**KIRKLEES METROPOLITAN COUNCIL
INVESTMENT & REGENERATION SERVICE**

DELEGATED DECISION TO DETERMINE PLANNING APPLICATIONS

Reference No:	2024/62/93600/E
Site Address:	103, Bedale Drive, Skelmanthorpe, Huddersfield, HD8 9EU
Description:	Erection of single storey side and rear extension, alterations to attached garage and erection of raised decking
Recommending Officer:	Elenya Jackson

DECISION - REFUSED

Project Proposed single storey front, side and rear extension, garage alterations and decking at 103 Bedale Drive Skeltonthorpe HD89EU Date 16/09/2024 Drawing Existing and proposed block plans Dwg No	F	2092	Scale 1:500
	R		
		2

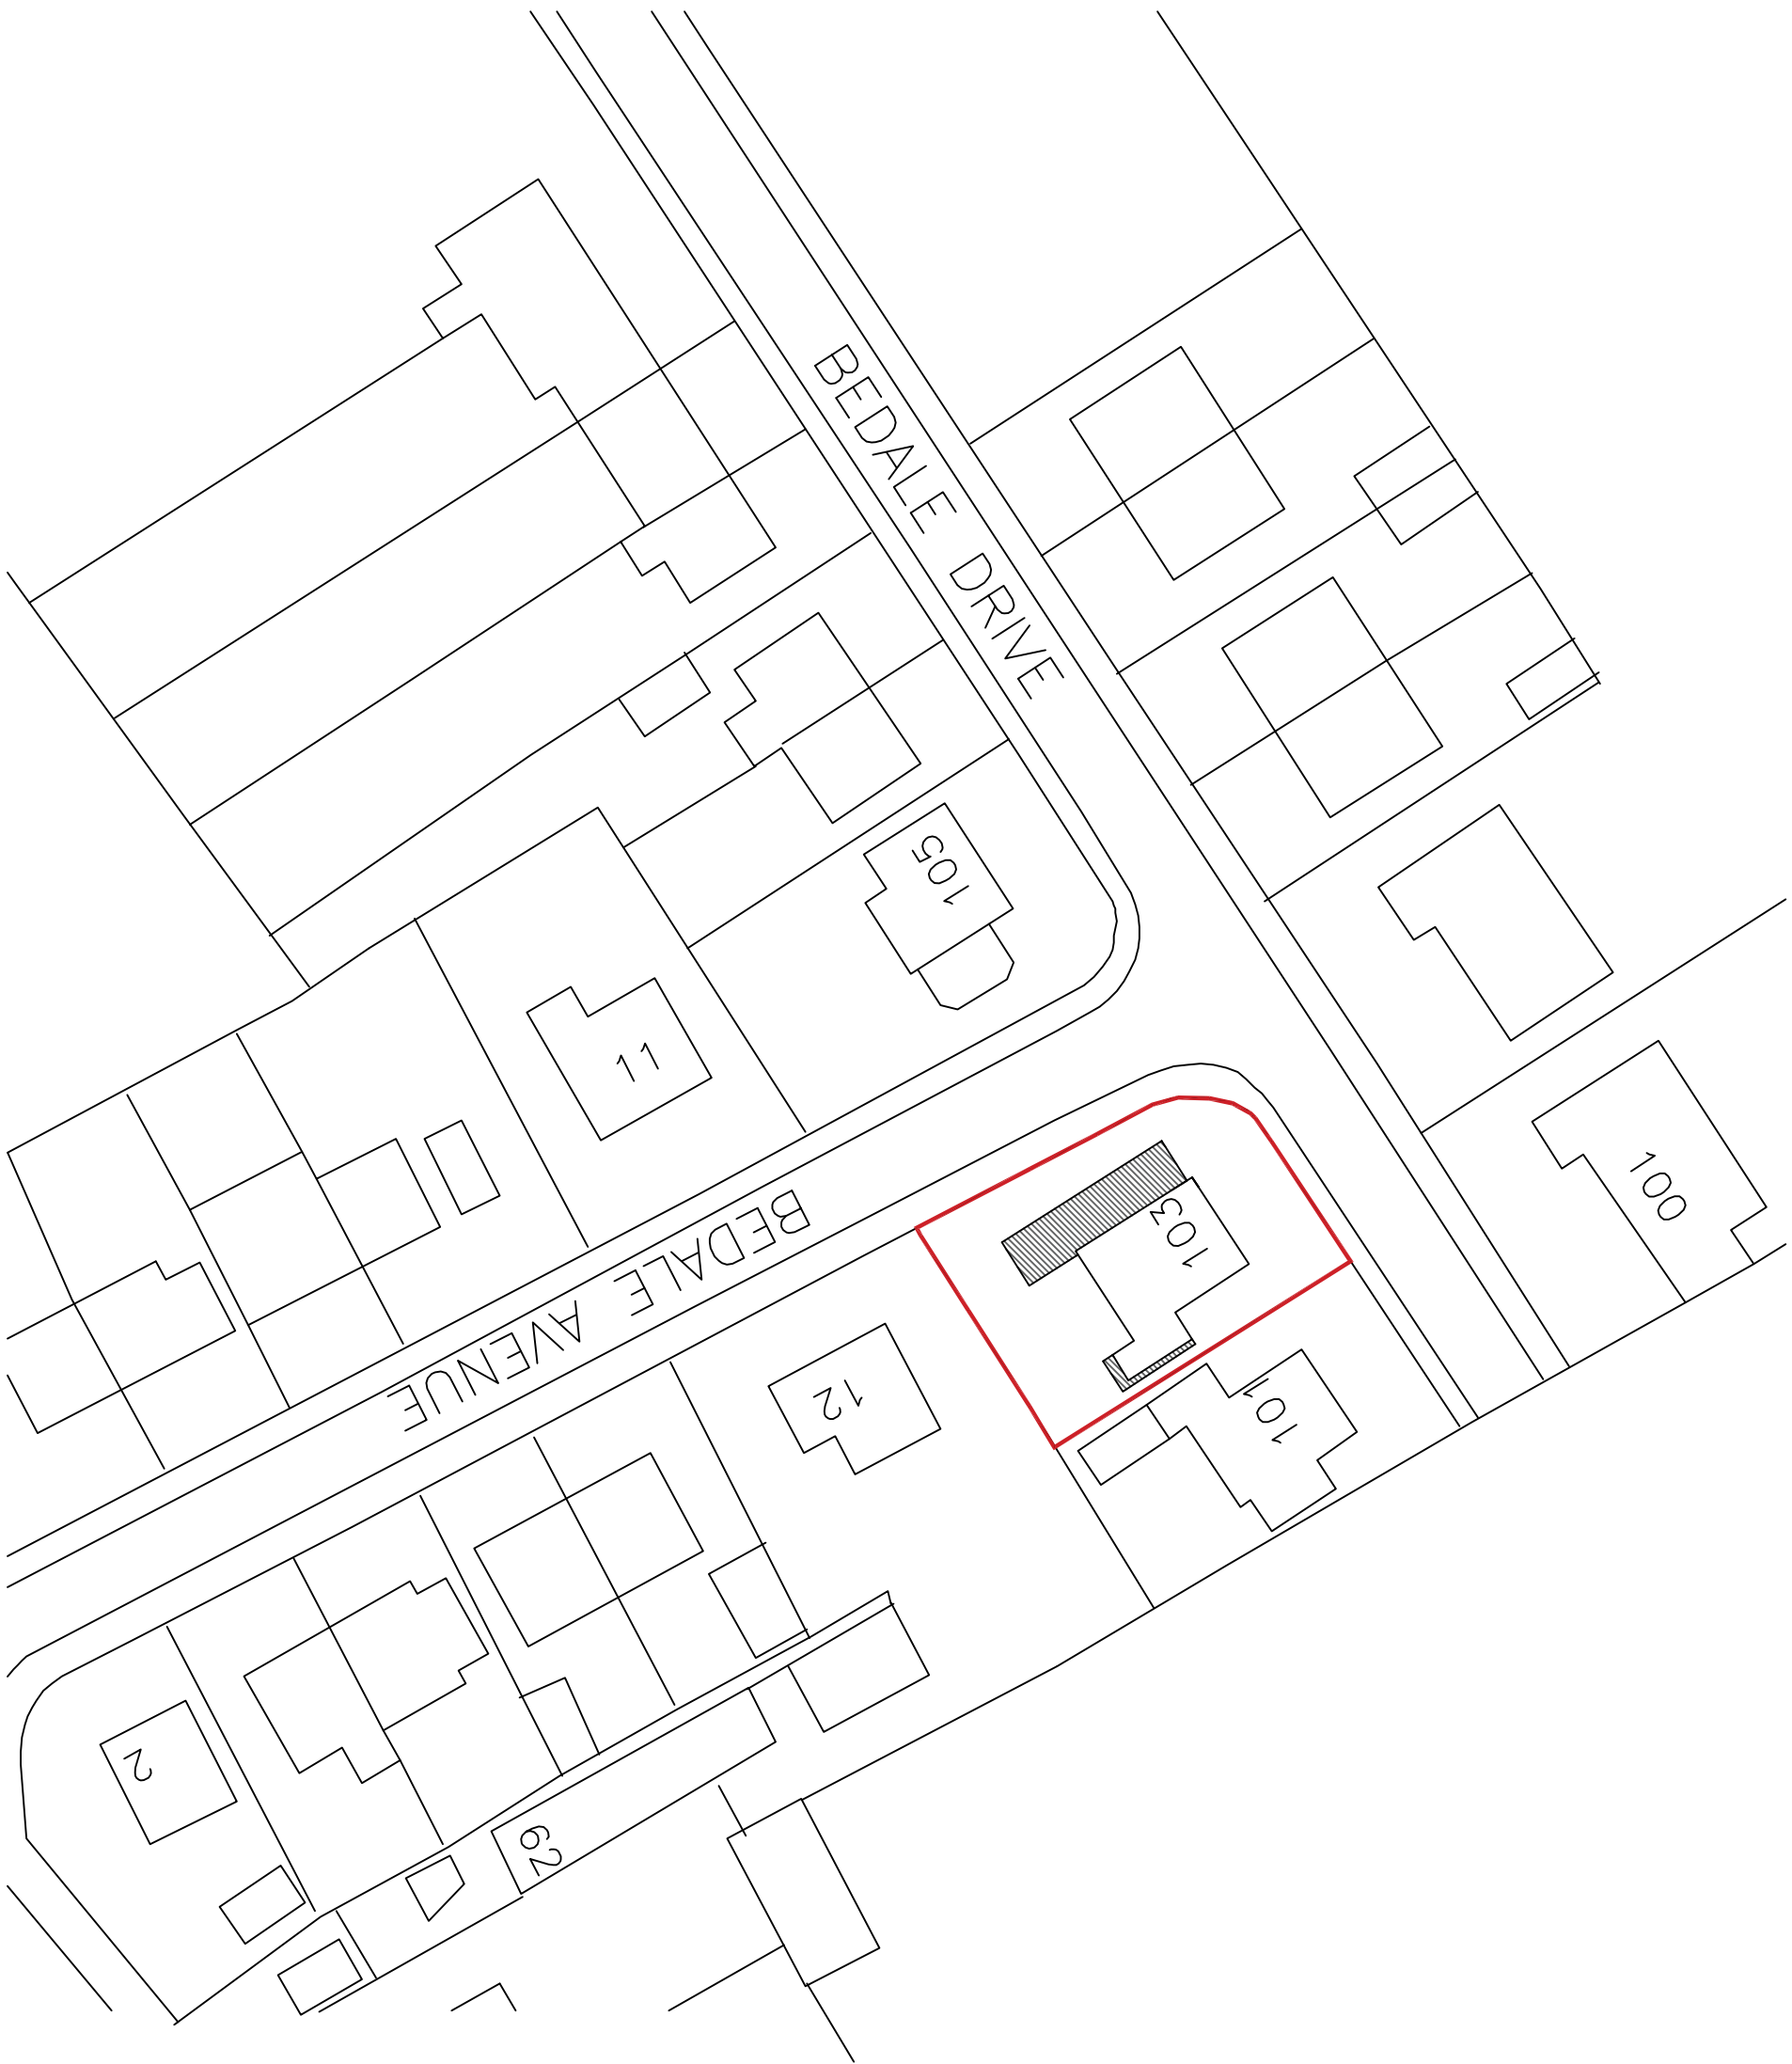
Previous applications at the site have been withdrawn following concerns raised by officers due to the width of the extension resulting in the building being significantly set forward of the build line along Bedale Avenue. It is noted that built form follows a similar building line along Bedale Avenue and the erection of any extension towards the highway would compromise that. As

set out in the Kirklees House Extensions and Alterations SPD where a group of buildings have a clearly defined building line this should be retained. To this end, the proposal has been reduced in width by 1.3m and despite being set a minimum of 2.8m into the plot, the proposal would still extend approximately 1.1m beyond the existing build line of Bedale Avenue.

It is considered that, due to the currently uninterrupted build-line within Bedale Avenue, the existing dwelling being situated within a highly prominent position within the street scene when coupled with the limited screening of the site, the single storey side extension would be read within the public realm as an obvious and obtrusive addition within the street scene which would fail to integrate with the host dwelling and the open character of the area contrary to the House Extensions and Alterations SPD and Policy LP24 of the Local Plan. Although the proposal would be set marginally the back from the principal elevation of the dwelling, it is considered that the resultant extension would be a considerable length of development along the south-western boundary of the site which has no screening and extends beyond the building line of the site. It is considered that the scale of the side extension would fail to appear subservient to the host dwelling and appear as a later addition that does not assimilate well within the street scene.

It is considered that the location of the proposal when coupled with its length, elevated position in the street scene and lack of screening from the public realm would result in an extension which is overly prominent, out of keeping with the street scene and fail to integrate with the host dwelling. In turn, would detract from the character of the area.
